Addendum #3

**The Parkside Neighborhood Center
and Affordable Housing
Mellen & Grant Streets,
Portland, Maine 04101**

February 25, 2004

This ADDENDUM supplements and amends the original Plans and Specifications dated January 29, 2004. This ADDENDUM is not a Change Order. It provides clarifications of or proposed changes to the Contract Documents. The Owner must approve all changes. A formal Change Order must be executed for any adjustments to the Contract Sum or the Contract Time

SKA-12  
rev. 2/25/04  
PARTIAL A5.2

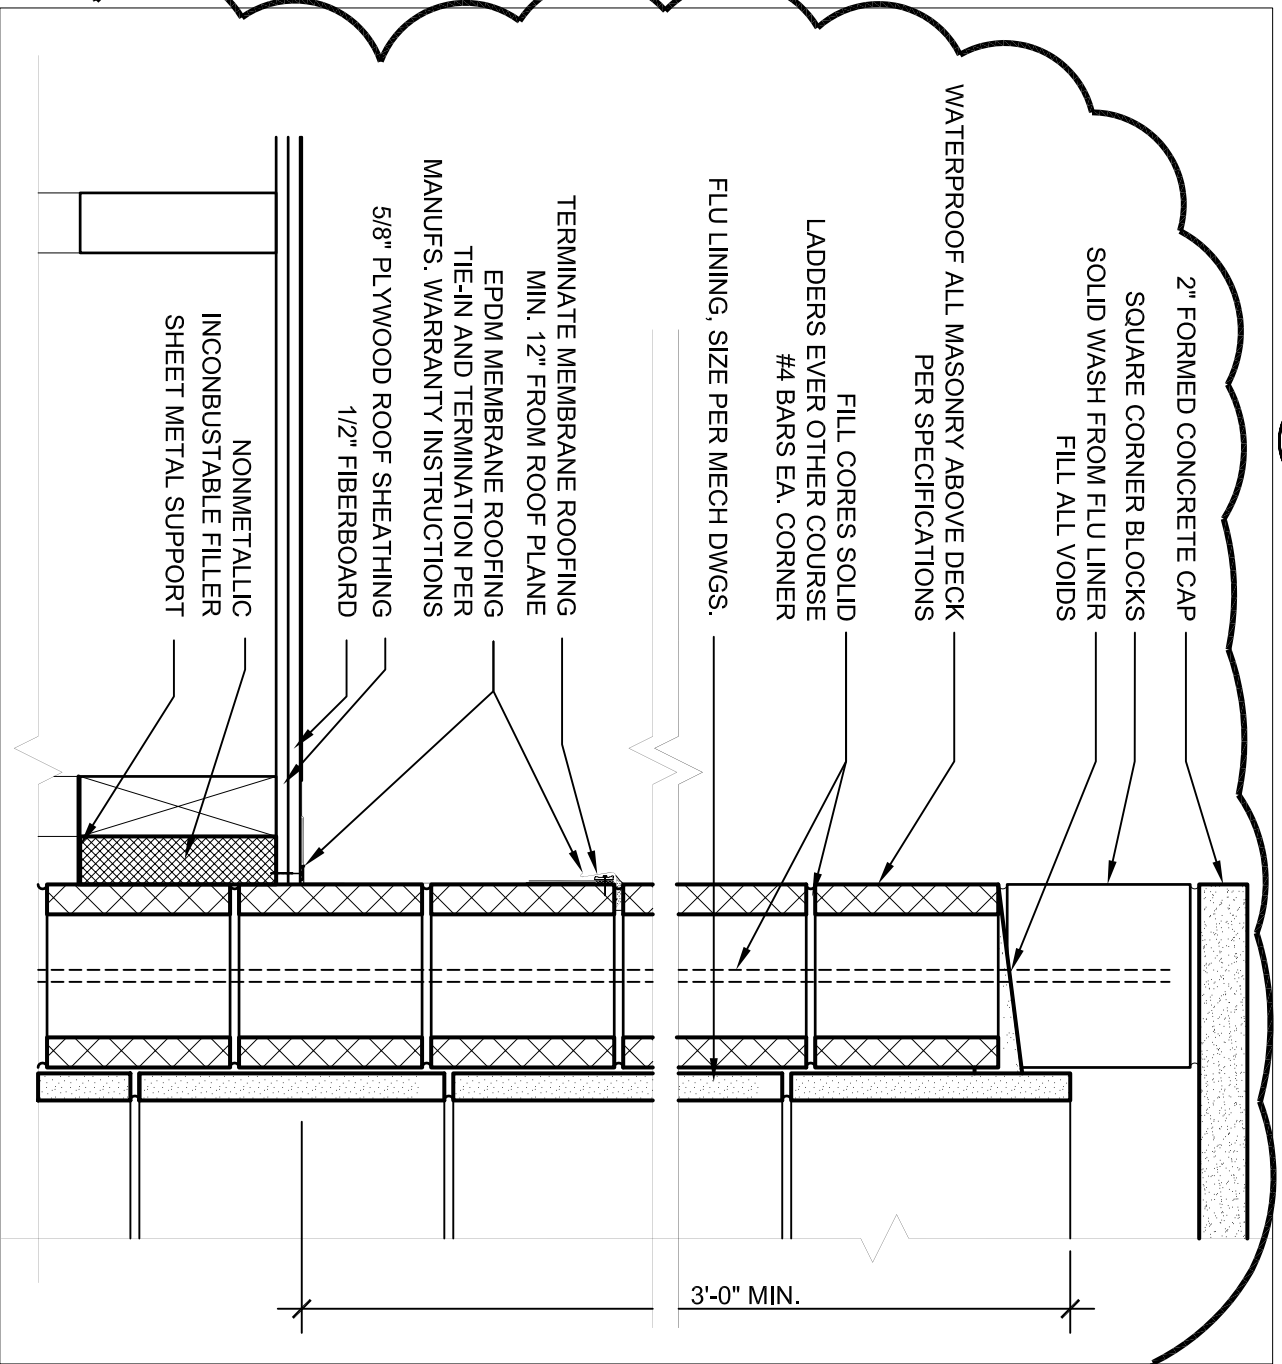
3-10	A1.1 A	1	REVISE chimney with attached revised SKA-13.
3-11	A1.0 B	1	REVISE chimney with attached revised SKA-14.
3-12	A1.1 B	1	REVISE chimney with attached revised SKA-15.
3-13	A5.2 A/B	1	REVISE chimney cap with attached revised SKA-15.
